WEST SUSSEX COUNTY COUNCIL CONSULTATION

TO:	Arun District Council FAO: Mr. S. Davis
FROM:	WSSC – Highway Authority
DATE:	21 October 2025
LOCATION:	Land Adjacent to Woodgate Nurseries Lidsey Road Aldngbourne PO20 3SU
SUBJECT:	AL/93/25/DOC Approval of details reserved by condition imposed under reference AL/129/21/OUT relating to condition 14 - construction & environmental management plan.
DATE OF SITE VISIT:	21 October 2025
RECOMMENDATION:	Advice

Title: Site Execution Plan

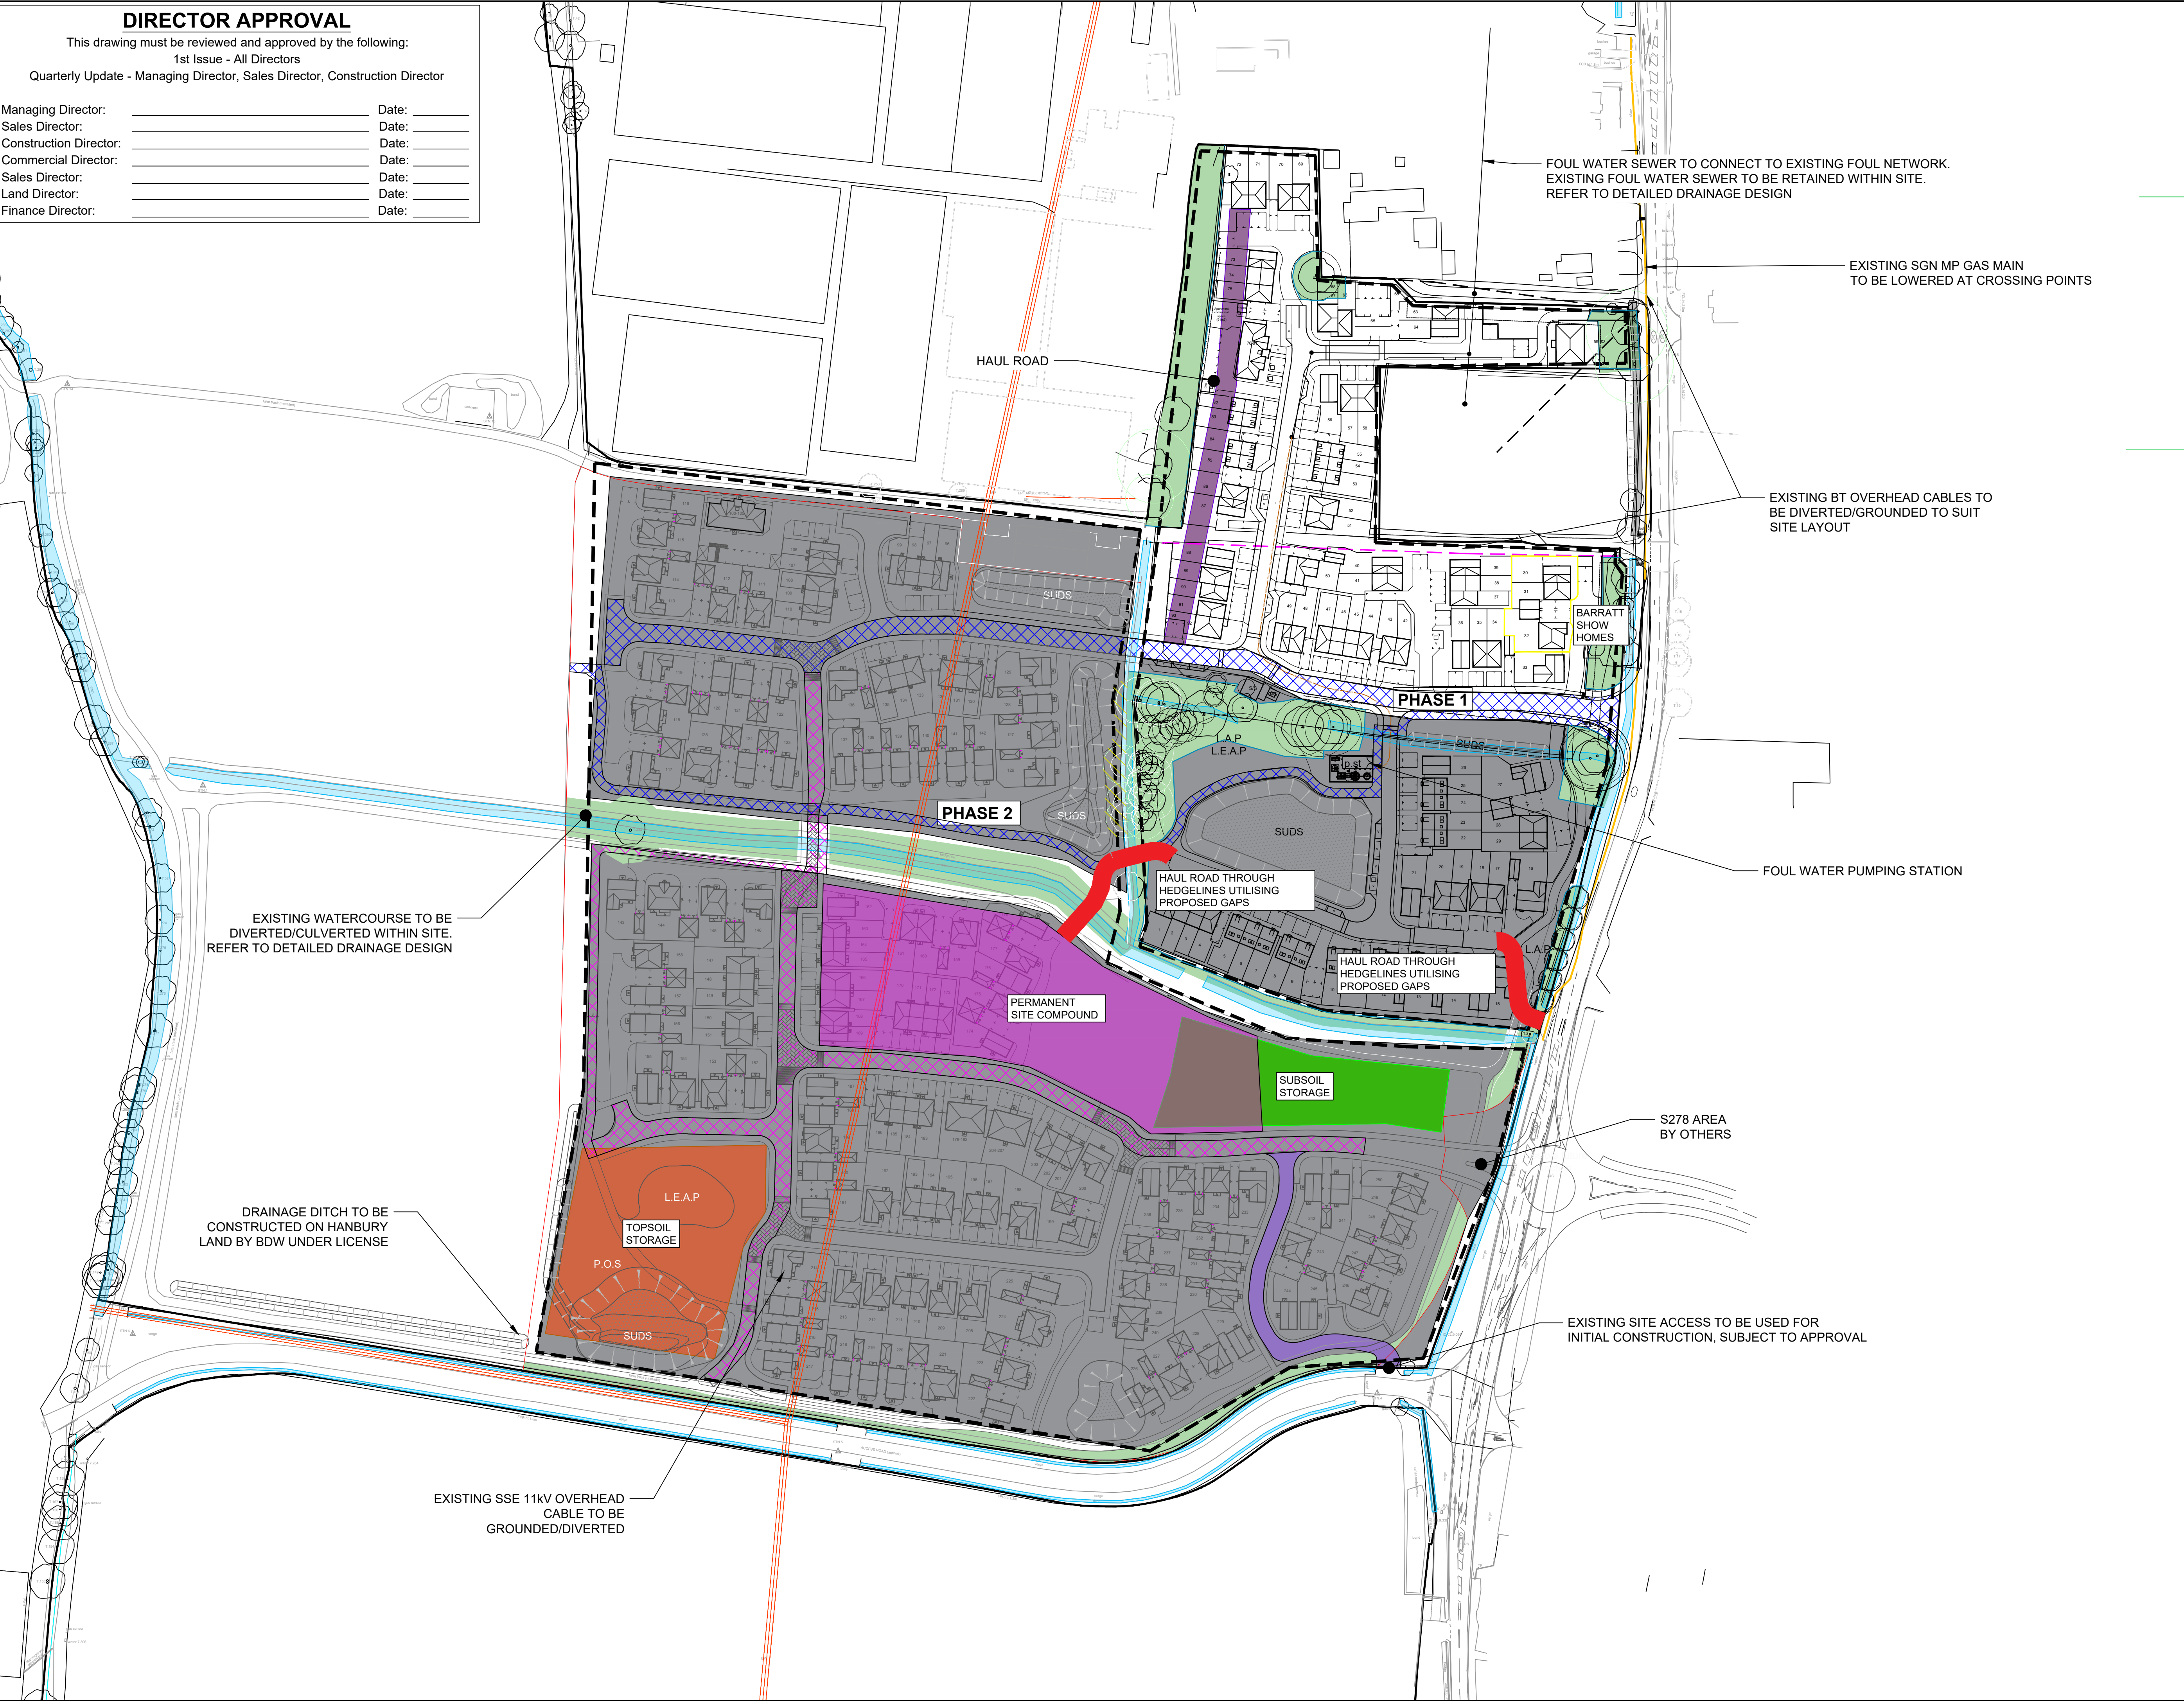
Point 1 - From reading through the amended version of the Construction Environmental Management Plan (CEMP) revision 'D', dated 8 October 2025, the applicant has only referred to the existing access to the site off Lidsey Road being used which they say will be used for a period of nine months until the new access to the site has been constructed, at which time all construction traffic will move to that new entrance and the existing access will be closed off to traffic. No reference to use of the access off the entrance leading to the former Lidsey Landfill is made in the latest Plan. However, reference to this access is still shown on Drawing No. H9390-SEP-01. If the latter is to be used in any way, it should be referenced in the final CEMP and the requirements set out by the Highway Authority in point 1 above (i.e. wheel washing and road sweeping) should be adhered to throughout the course of it being used.

Wheel washing and road sweeping for this access should be undertaken in accordance with the details provided in the latest CMP (paragraph 7).

Haul Road
Visibility Splays
Scale 1:1000@A1

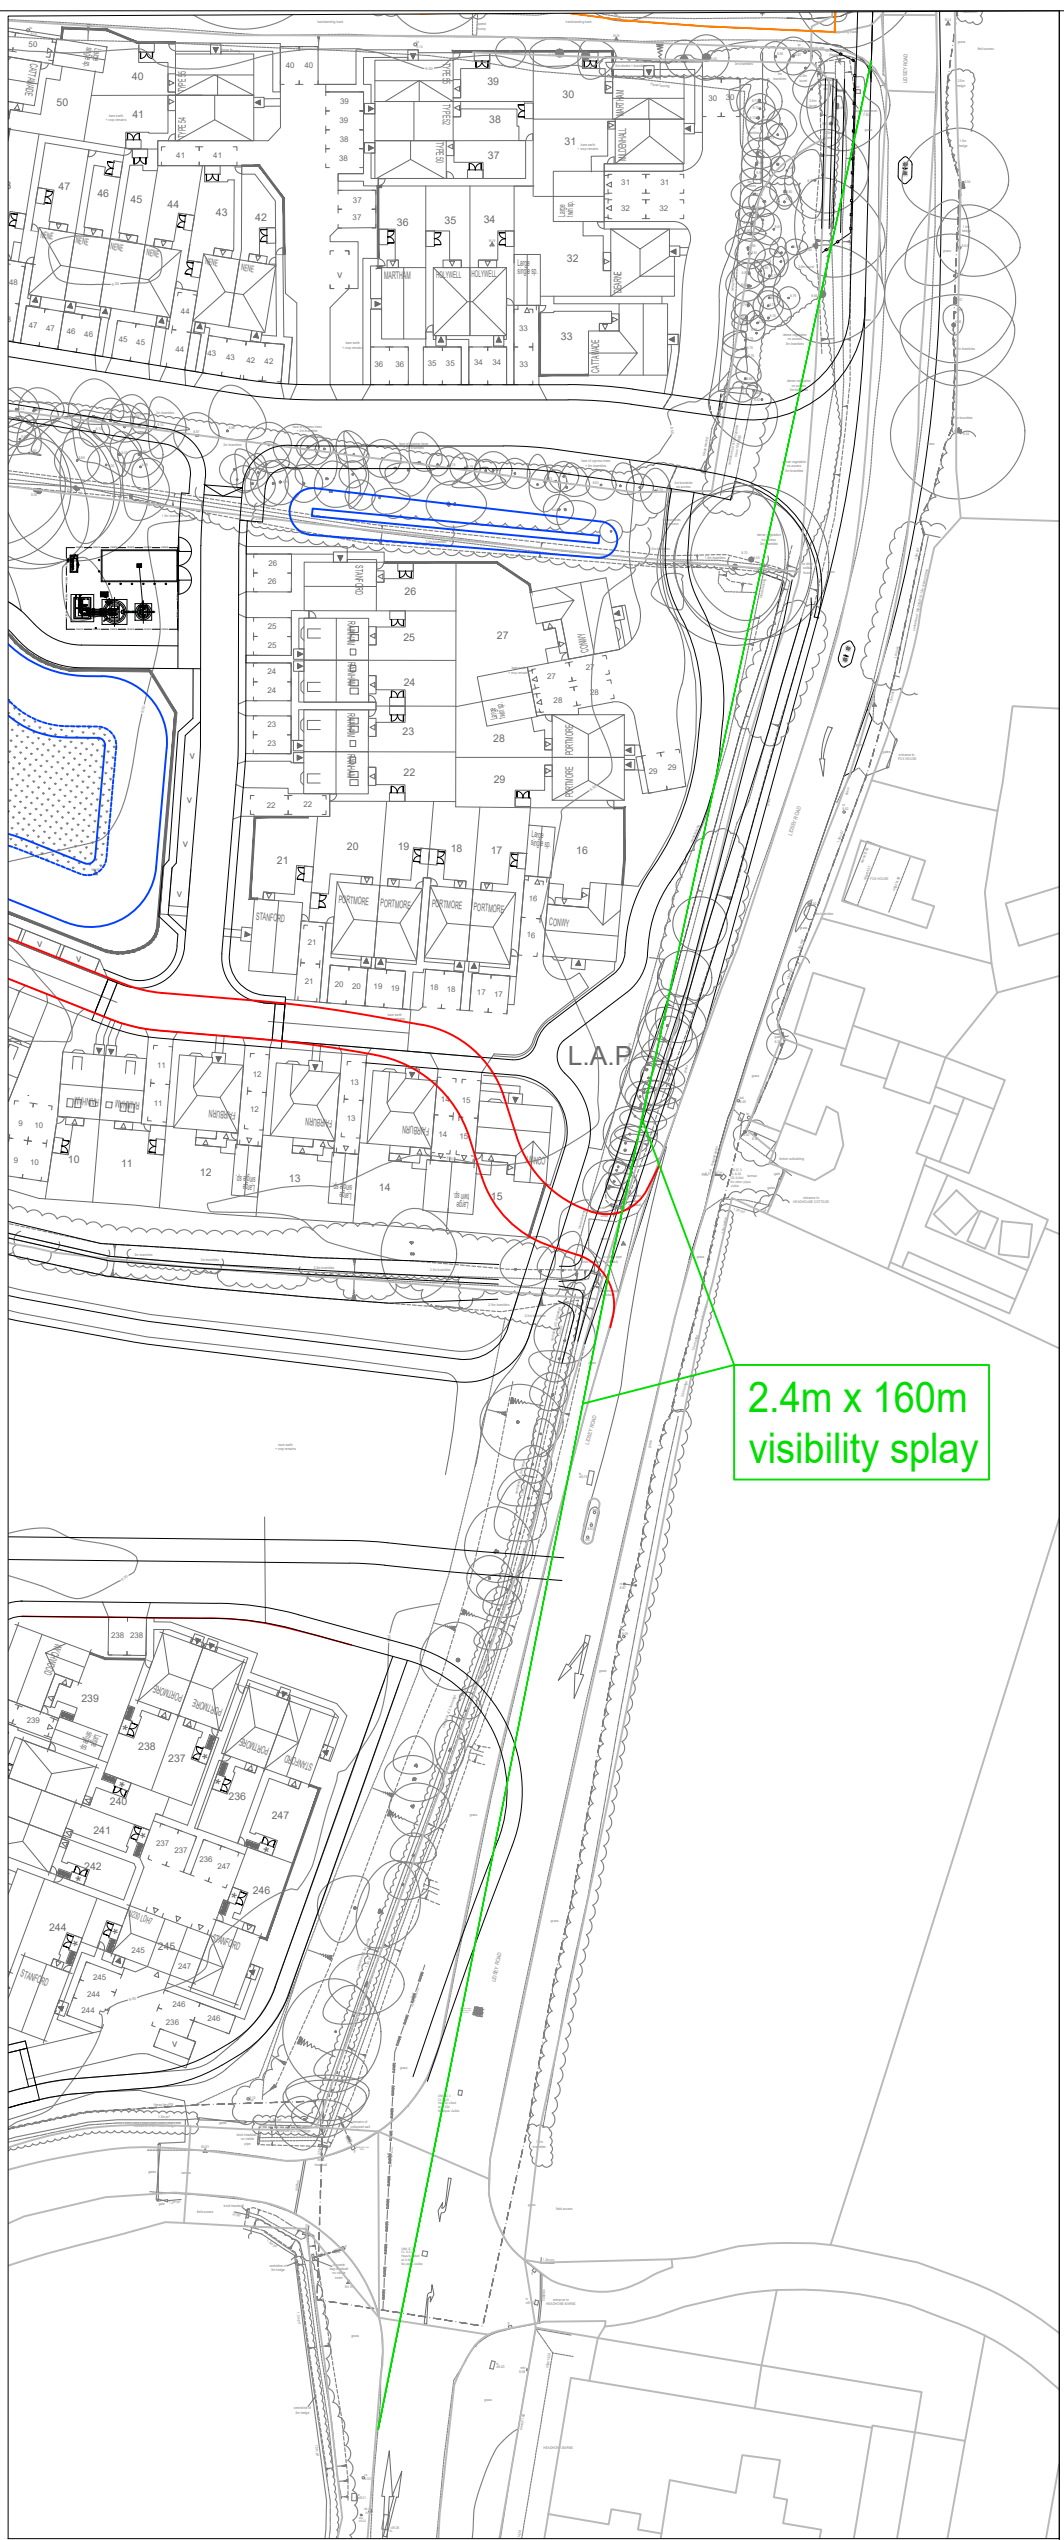
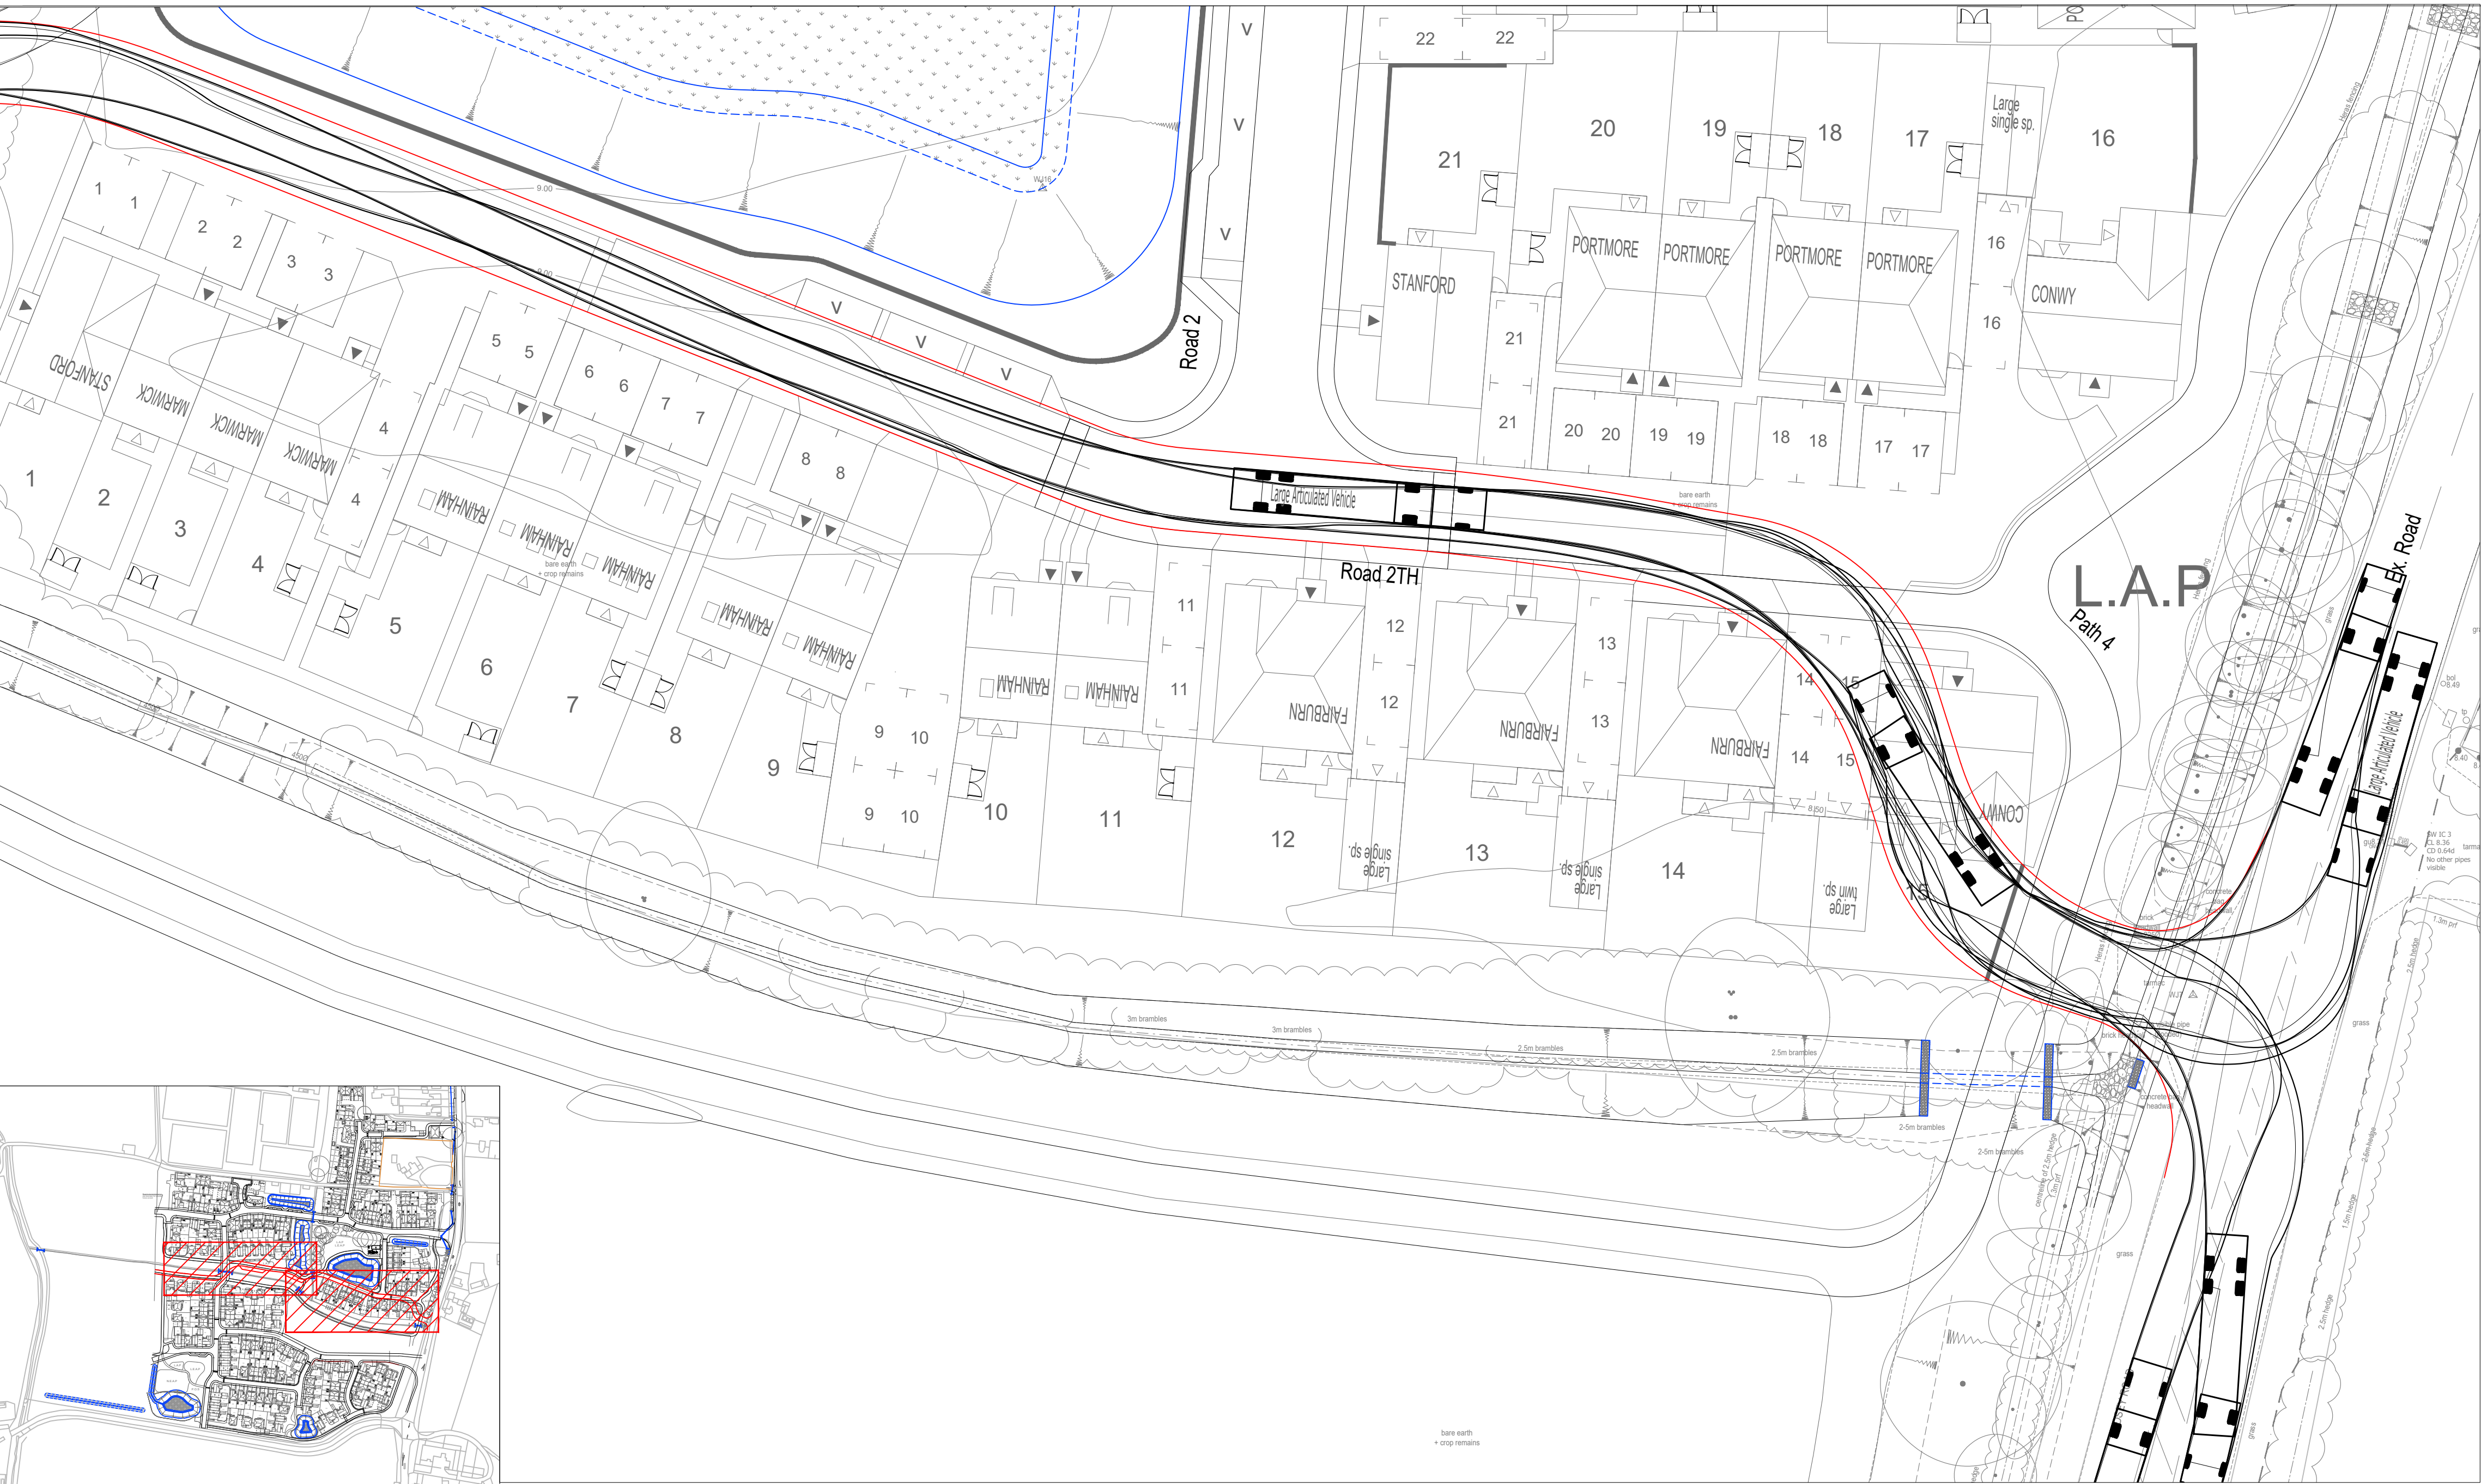
As noted in the previous Highway Authority comments and repeated here, the new CEMP includes reference to use of an existing access found approximately mid-way between the Lidsey Landfill access and the proposed new site access. In response to the previous comments made by the Highway Authority, the applicant has produced Drawing No. DS_0707_15/INF/502. This plan shows visibility splays in both directions (160m) for the posted speed limit of 50mph, with the splays taken to the nearside edge of the carriageway from a point 2.4m back from the edge of the carriageway. These splays must be maintained throughout the course of this access being used.
